**Your Ref:**  
**Our Ref:** AW/143/08/  
**Please ask for:**  
Mr M Porter

22nd July 2008

Proposed extension to music room and lift shaft to first floor - resubmission following  
refused application AW/83/08/  
15 Waters Edge Aldwick

PROPOSED EXTENSION TO MUSIC ROOM AND LIFT SHAFT TO FIRST FLOOR
15 WATERS EDGE ALDWICK BOGNOR REGIS
this drawing to be read in conjunction with C.J.WOOD calculations and details 1-9

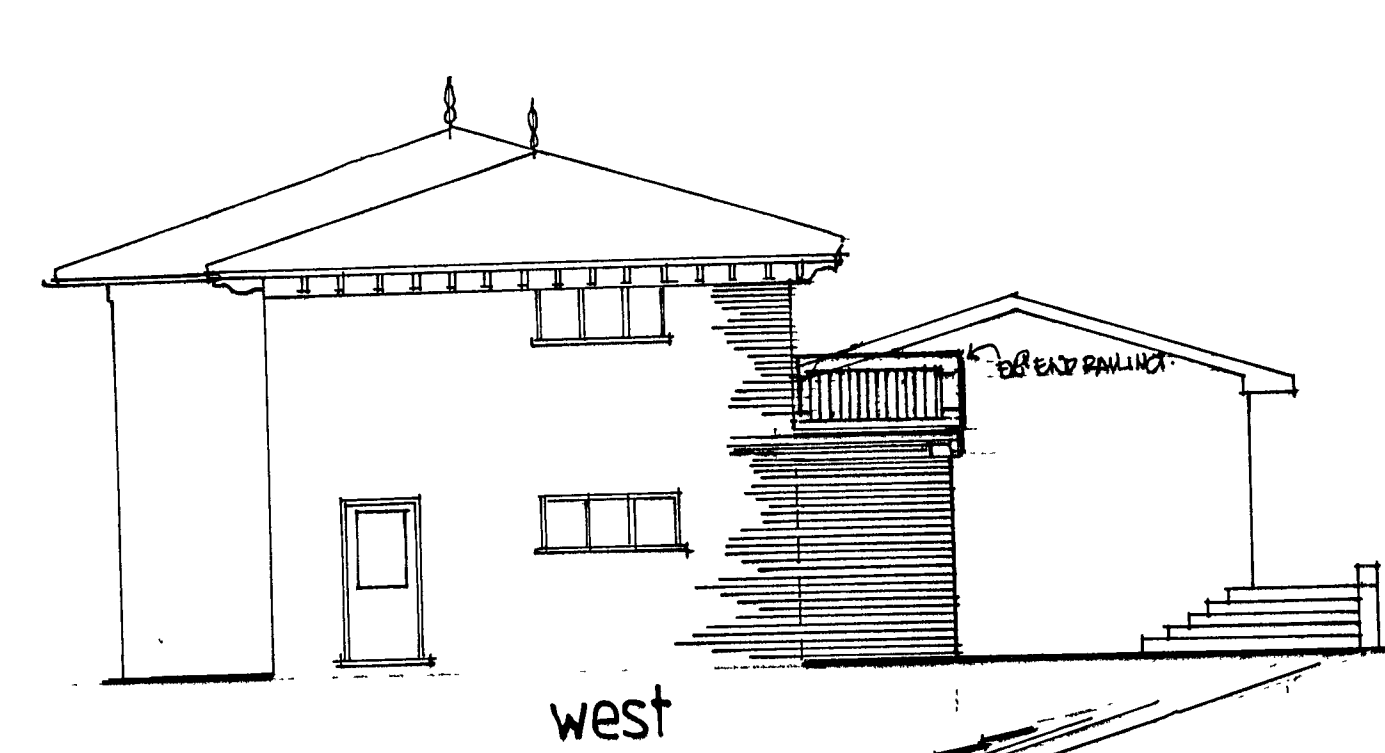
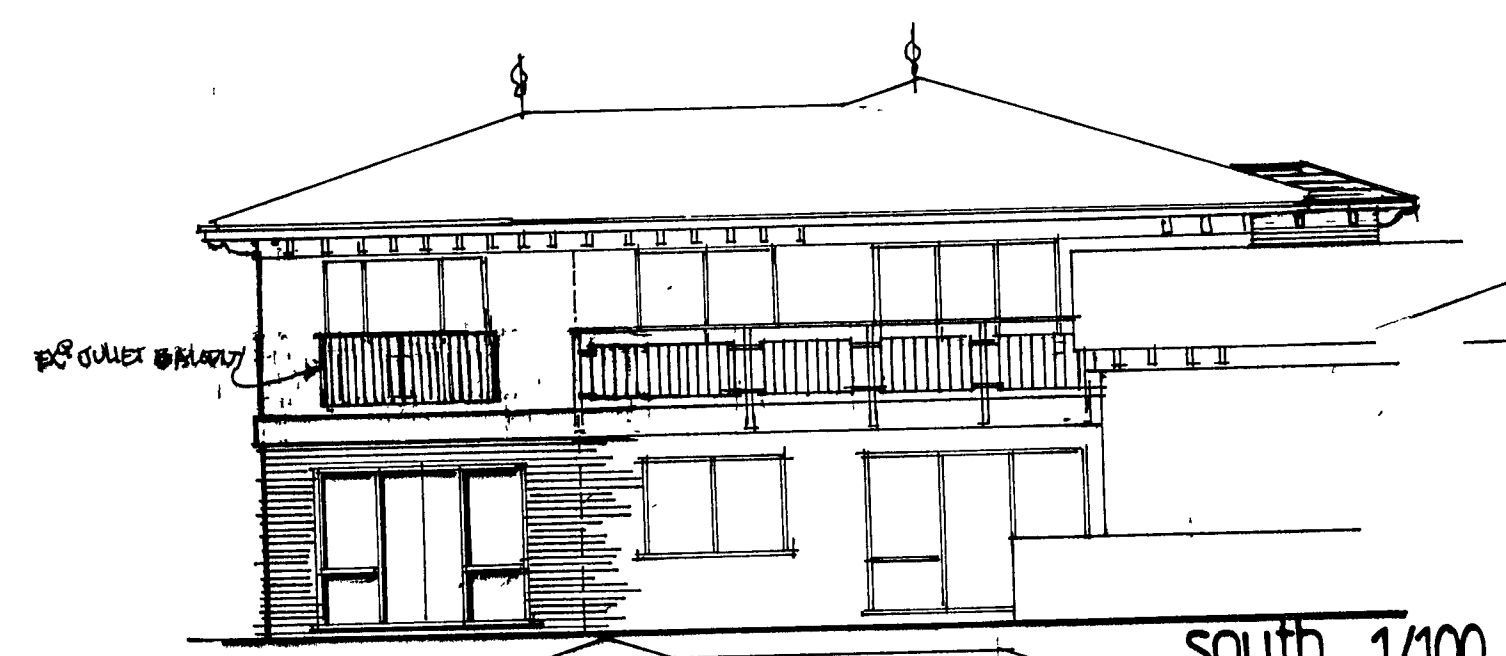
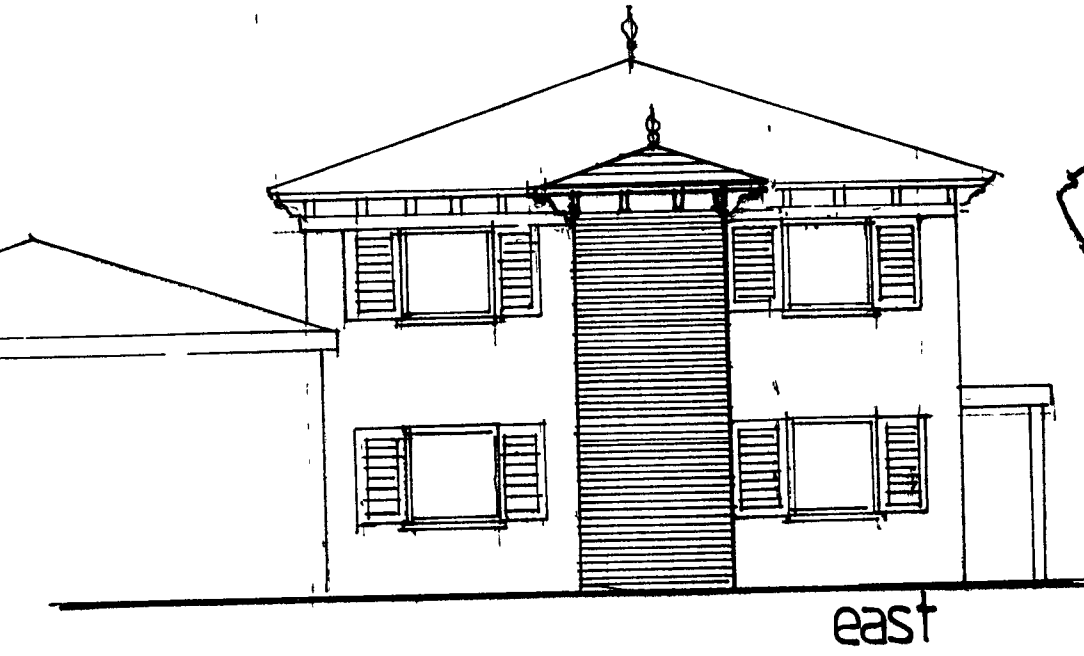
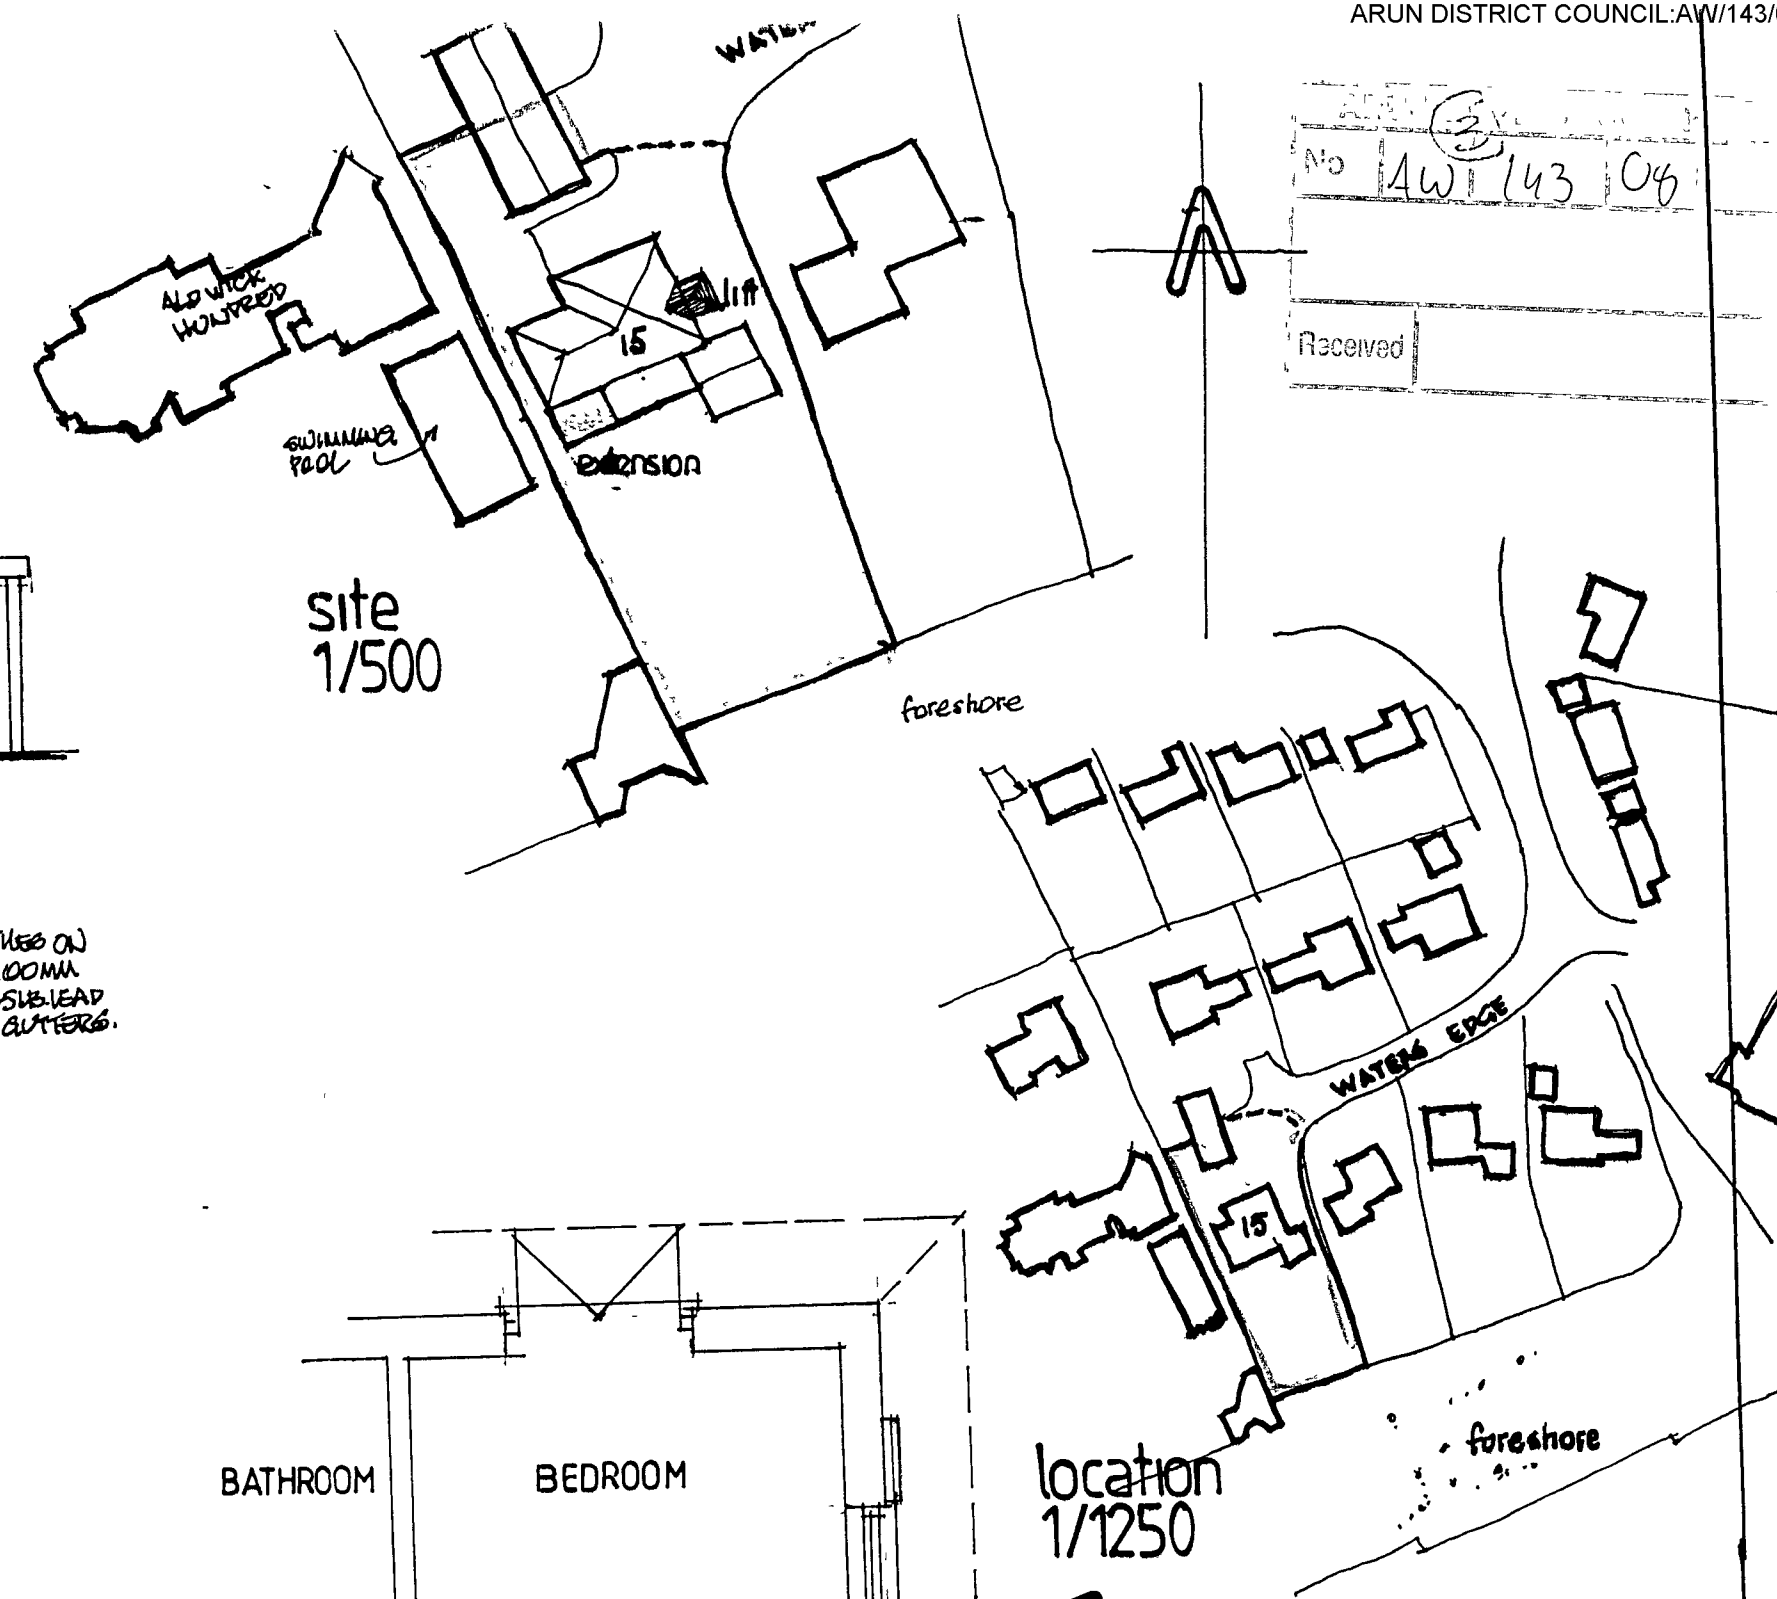
*Members believe this development is unneighbourly as there is a possibility of unacceptable overlooking and loss of privacy and likely noise intrusion onto the neighbouring property to the west. Members also thought that the lift shaft and the changed roofline would be out of character with other properties in the locality.* ☐
